DEVELOPMENT REVIEW BOARD
TRANSPORTATION DEVELOPMENT

DRB Project Number: 1004919
North 2nd St Business Center

SUBJECT: Preliminary/ Final Plat

Application #: 18DRB-70128

SUBDIVISION PLAT OF  
TRACT 3-A  
**SECOND STREET BUSINESS CENTER**  
PROJECTED SECTION 33, T 11 N, R 3 E, N.M.P.M.  
ELENA GALLEGOS GRANT  
BERNALILLO COUNTY, NEW MEXICO  
FEBRUARY 2018

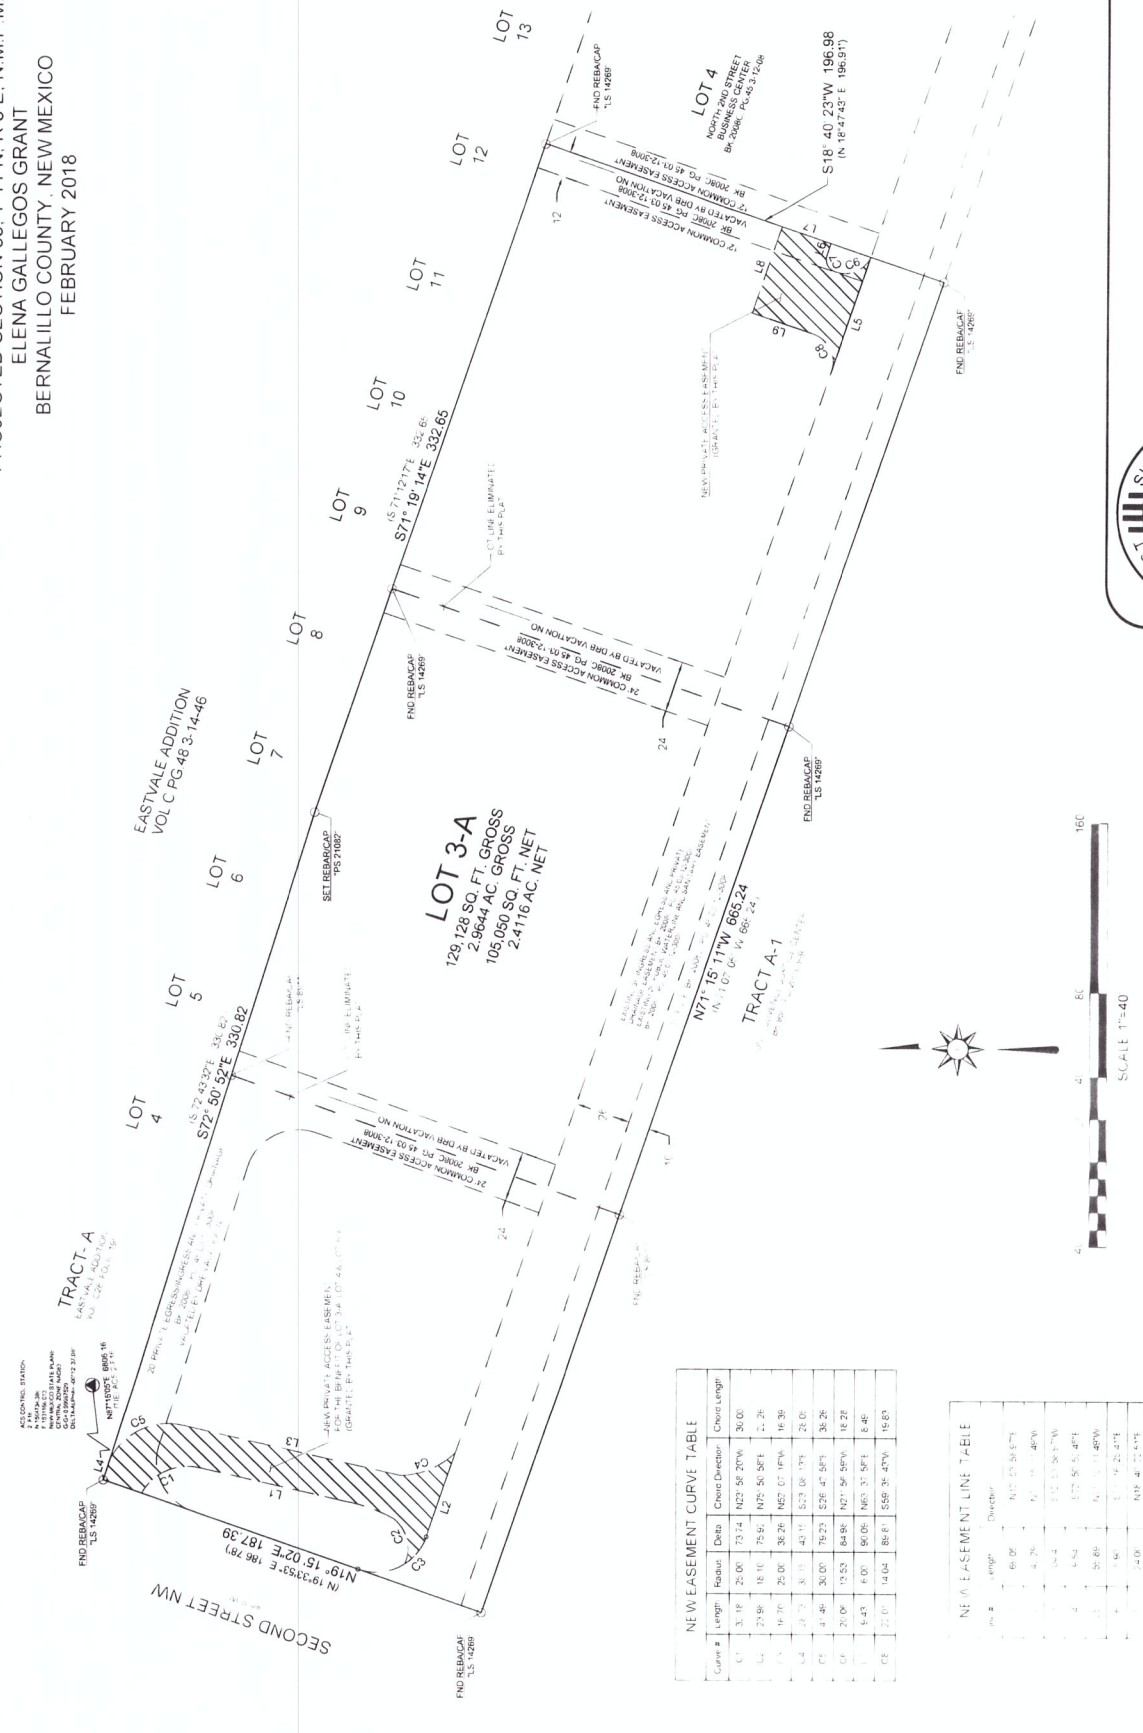
1. You mention a vacation of easements, has an application for the vacation been provided?
2. Provide a sidewalk exhibit showing the location, width, and defining the distance from back of curb to the property line. Right of way dedication may be required.
3. Access easements need to be clarified. It appears the site parking lots are connected and additional easements are needed.
4. For final plat, any access easements need to be shown with all beneficiaries and maintenance responsibilities listed.

- Need a signature line for Code Enforcement
- Location map needs to be readable. Currently there is no information except the subject site.
- Needs owners signature and notary
- City surveyor's signature is required with submittal.
- Add vacation information to the plat (18DRB-70128)
- The justification letter must address the vacation findings of the subdivision ordinance (14-14-7-2(B)). It is the responsibility of the agent/applicant to justify the request.
